Two storey side extension to form 2 No. self contained flats, replacement of ground floor front window with bay window, flat roof canopy to side elevation, porch extension to rear elevation, first floor balcony & insertion of flush fitting sun pipe. This application affects the character & appearance of The Steyne Conservation Area.

9B Waterloo Square Bognor Regis

Thank you for your internet comments made on 10th January 2019 which has been recorded as **'no objection'** with the comments as follows:

PROPOSED ELEVATIONS

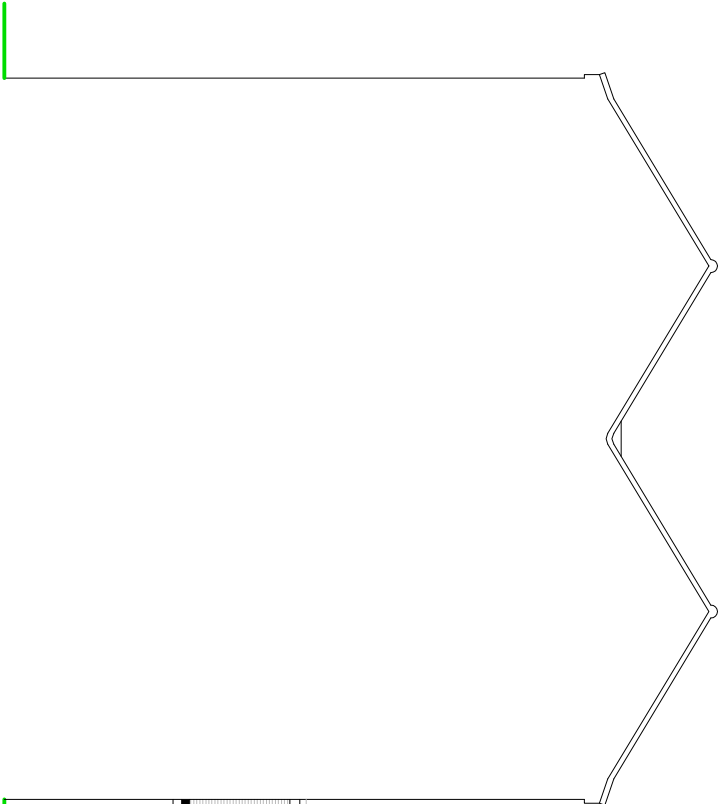
NO OBJECTION The Committee were pleased to see the balcony being restored to its former glory and of a design that was more in keeping with the character and appearance of The Steyne Conservation Area.
